City of Albuquerque Stormwater Construction Site Inspection Report

Project Name and Location	Jefferson Middle School Ph 1 Music Bldg Lomas and Grant		
Site Contact Name & Agency	of Jason (Myron Johnson) Anchor Bank APS	Contact Phone #	505 276-9020
Date of Inspection	7-6-16	Start/End Time	11:05/11:45
Inspector Name, COA Dept.	Curtis Cherne, Stormwater Quality		
Inspector Phone / E-mail	505-924-3420/ccherne@cabq.gov		
Inspector Qualifications	Qualified Compliance Inspector of Stormwater- Stormwater One		
Describe Present Phase of Construction	Bldg vertical applying stucco, utilities		
Type of Inspection:	<input type="checkbox"/> Regular <input type="checkbox"/> During storm event <input type="checkbox"/> Post-storm event (> 0.5 inch) <input type="checkbox"/> 311 / Complaint Response <input type="checkbox"/> Follow-Up

From: Cherne, Curtis
Sent: Wednesday, July 06, 2016 3:50 PM
To: 'johnson_my@aps.edu'
Cc: 'kchavez@e2rc.com'
Subject: Jefferson Middle School Music Bldg SWPPP inspection
Attachments: track-out_girard.jpg; girard_entrance_closeup.jpg; gap_needs_BMP.jpg; cement_pollution.jpg; girard_entrance.jpg

CONSTRUCTION ENTRANCE STABILIZATION
SCALE: 1" = 10'-0" HORIZ.
1" = 2'-0" VERT.

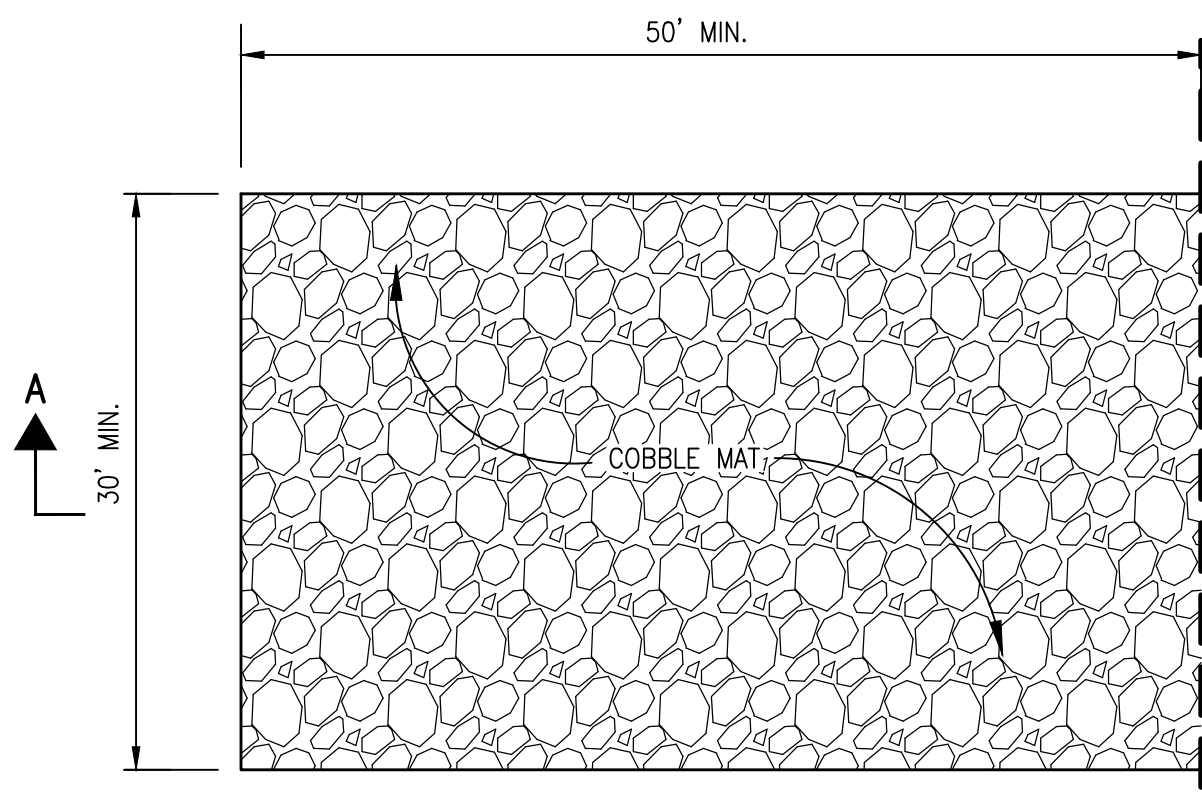
1. Track-out onto Girard Blvd. Girard (back to high-point on site) should be swept to remove sediment.
2. The ESC plan shows the stabilized entrance off of Girard Blvd. It is OK to move it, but it looks like this one is still being used and there is no stabilized entrance. Most of the workers are entering/leaving off of Lomas Blvd, but the utility contractors are using Girard. If this location is to be used, a stabilized entrance is to be installed.
